**Project ref:** M25 junction 10/A3 Wisley  
interchange improvement – TR010030

**Our ref:** WA/2019/126852/04-L01

**Date:** 28 January 2020

**Application by Highways England for an Order Granting Development Consent for the M25 Junction 10/A3 Wisley interchange improvement project**

**Figure 2.1: Environment Agency Flood Zone mapping and watercourse location plan**

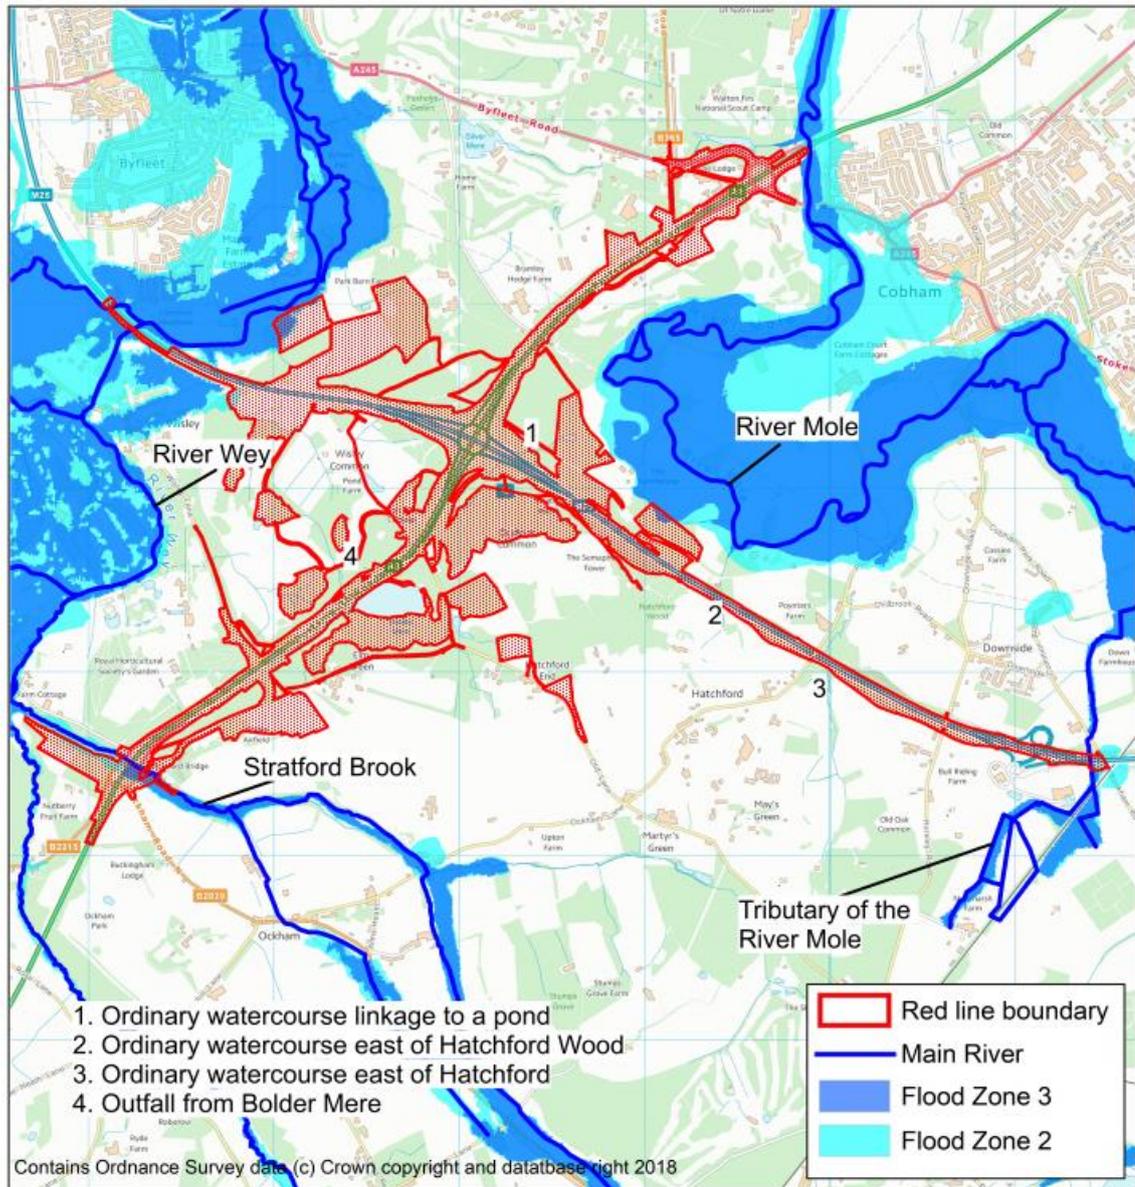
- 2.2 We maintain that the applicant should provide further information to demonstrate that their use of Flood Zone 2 as a proxy for a 1 in 100 plus climate change flood extent is appropriate for this development.

- 2.3 We acknowledge that it is possible that a 1 in 100 plus 70% allowance for climate change flood extent would not extend beyond the boundary of Flood Zone 2, but this has not been demonstrated by the applicant. There remains an inherent risk that a climate change extent could be a wider extent than Flood Zone 2 and therefore has not been appropriately assessed in the FRA.

- 1.3.3 In summary for our outstanding issue, the applicant has used the extent of Flood Zone 2 (as shown on the Flood Map for Planning: <https://flood-map-for-planning.service.gov.uk/>) as a 'proxy' for the extent of a 1 in 100 plus 70% allowance for climate change (the highest allowance in the Thames catchment). This assumes that the flood extent for a 'with climate change' event would not extend beyond the mapped Flood Zone 2, but no evidence has been provided to support this assumption.
